# CITY OF ALBUQUERQUE

April 26, 2016

**RE: Lot 7, Block 11 Volcano Cliffs Unit 18  
6524 Petirrojo Rd NW  
Grading and Drainage Plan  
Engineer's Stamp Date 4-20-16 (D10D003H6)**

ENGINEER'S SEAL 4/20/16 DAVID SOULE P.E. #14522	LOT 7, BLOCK 11, UNIT 18 VOLCANO CLIFFS SUBDIVISION	DRAWN BY JDG DATE 04-21-2016
	GRADING AND DRAINAGE PLAN	SHEET # 1 OF 1
 Ro Grande Engineering 1606 CENTRAL AVENUE SE SUITE 201 ALBUQUERQUE, NM 87106 (505) 872-0989		JOB #

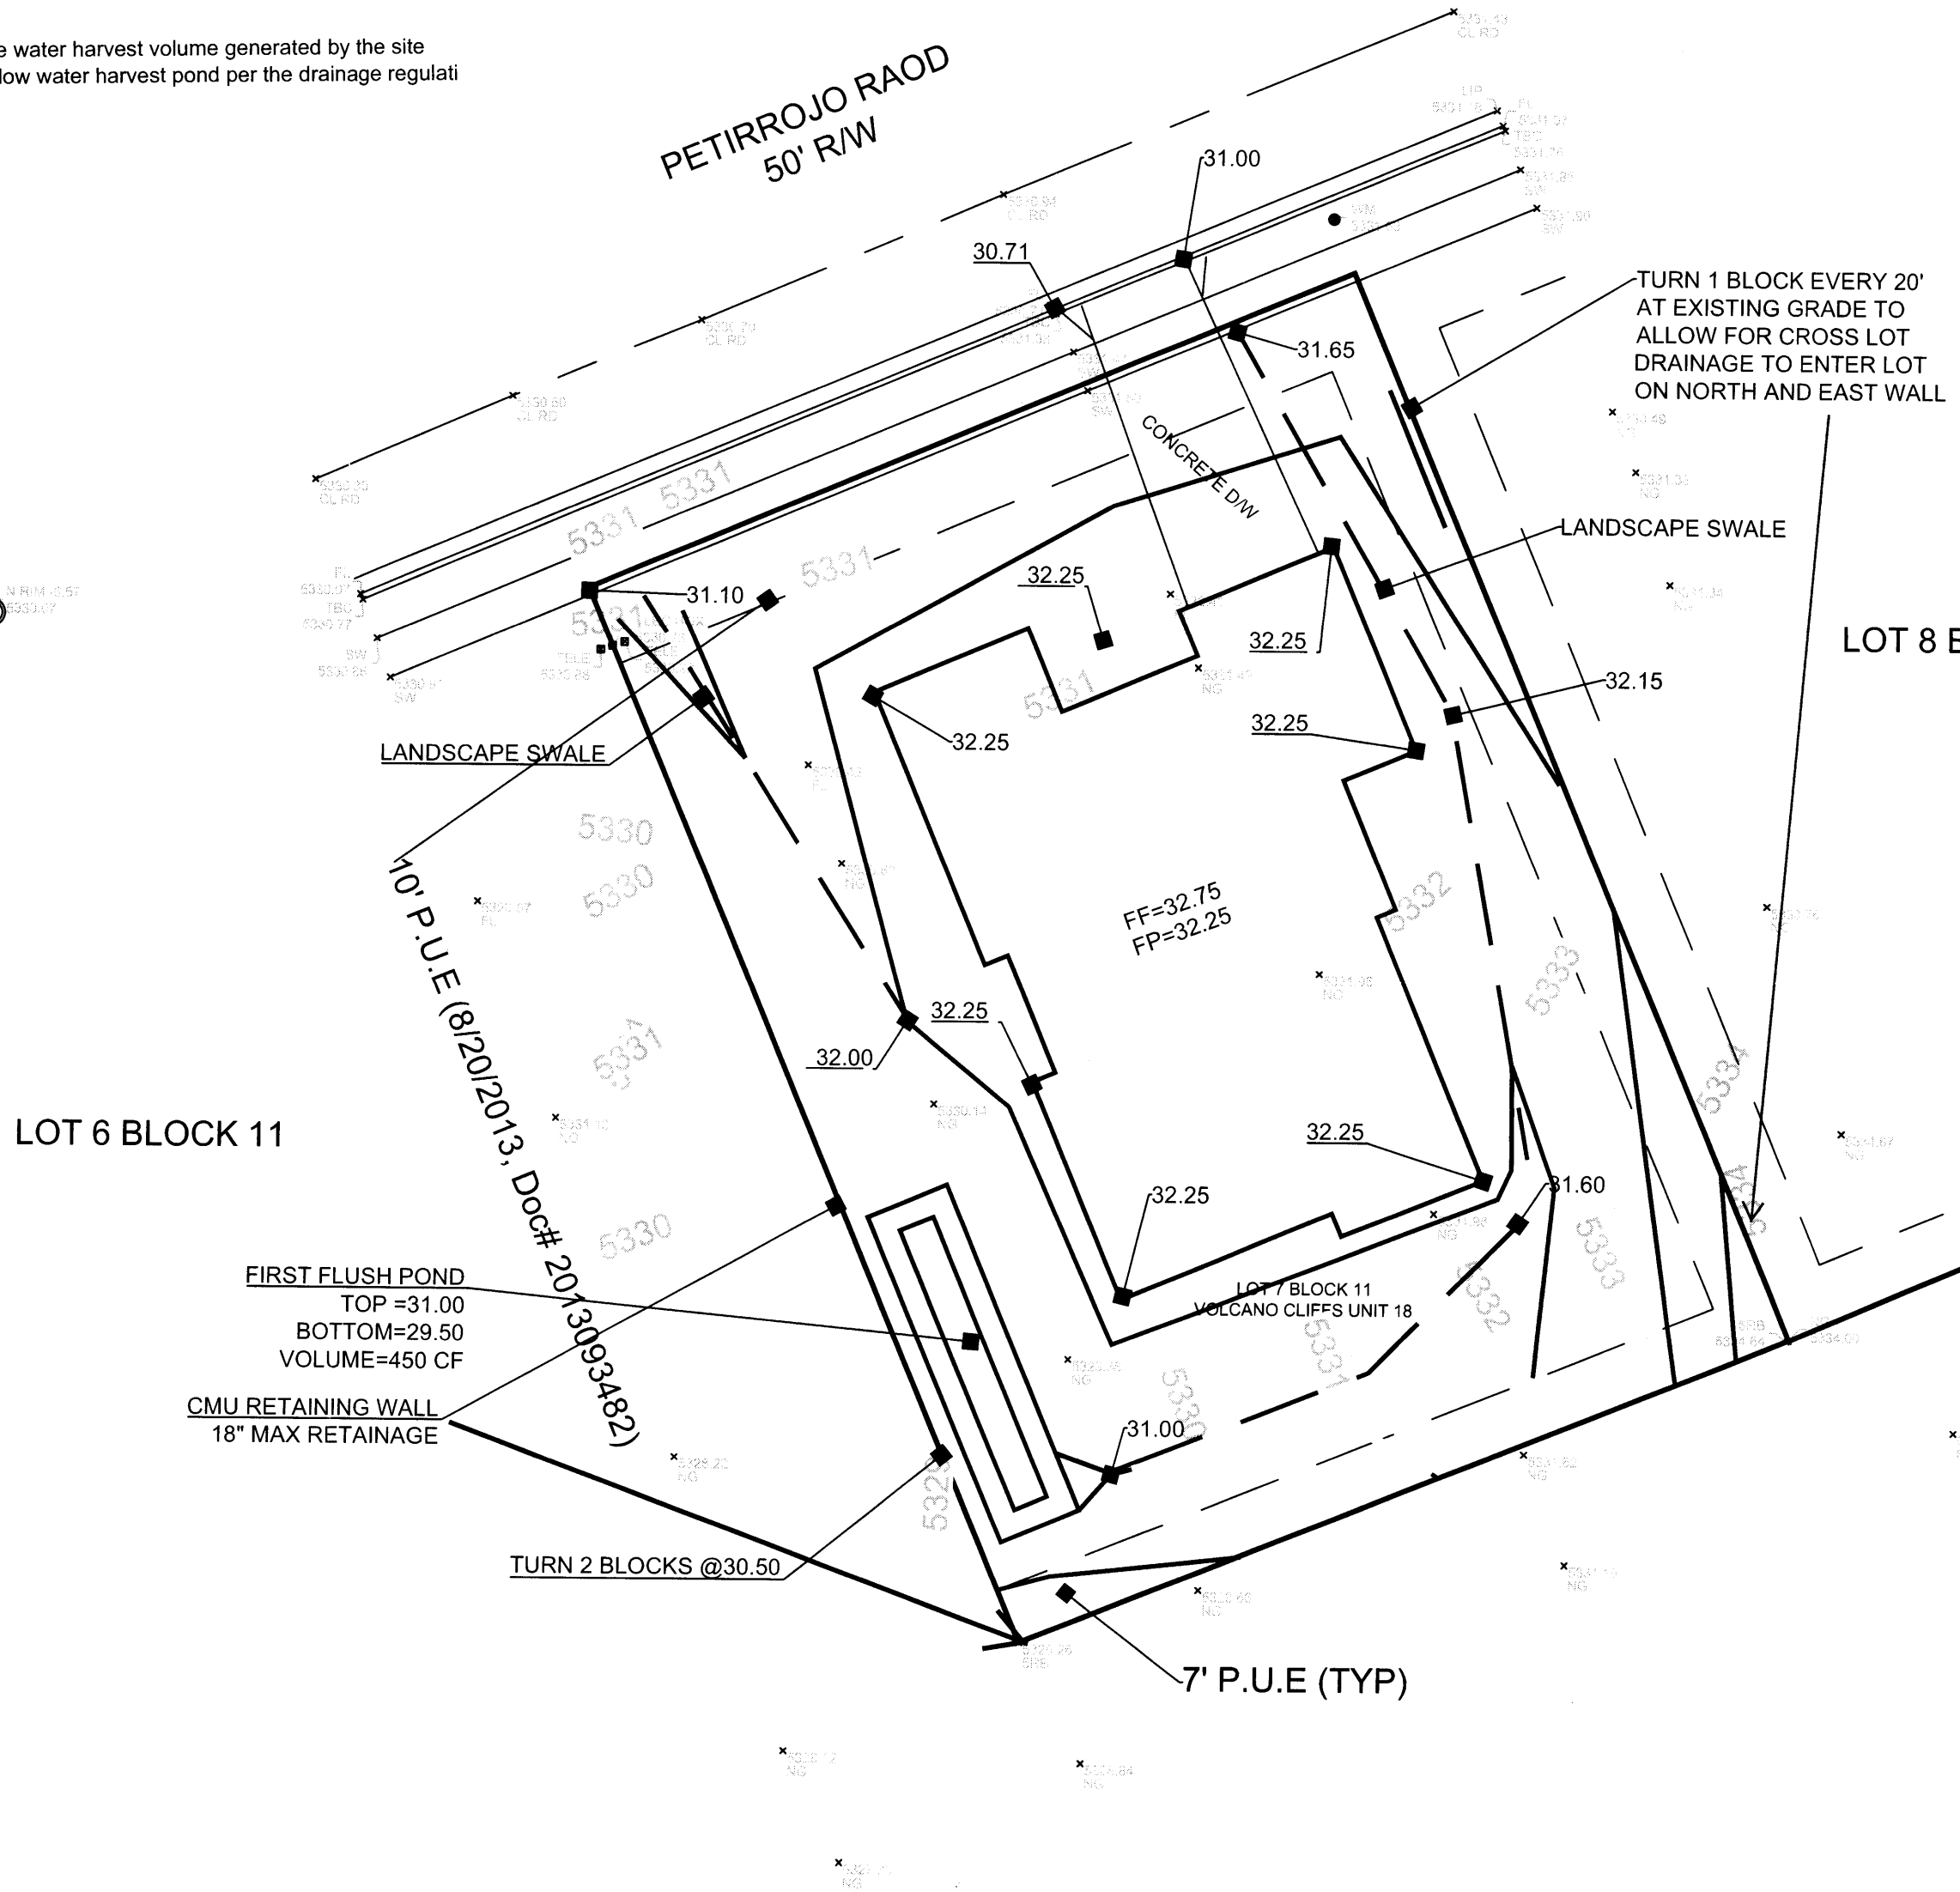
Please attach a copy of this approved plan to the construction sets in the permitting process prior to sign-off by Hydrology. A separate permit for the wall is required. Attach this approved plan to the wall permit set. Place all turn blocks 3" above grade for sediment control and landscaping.
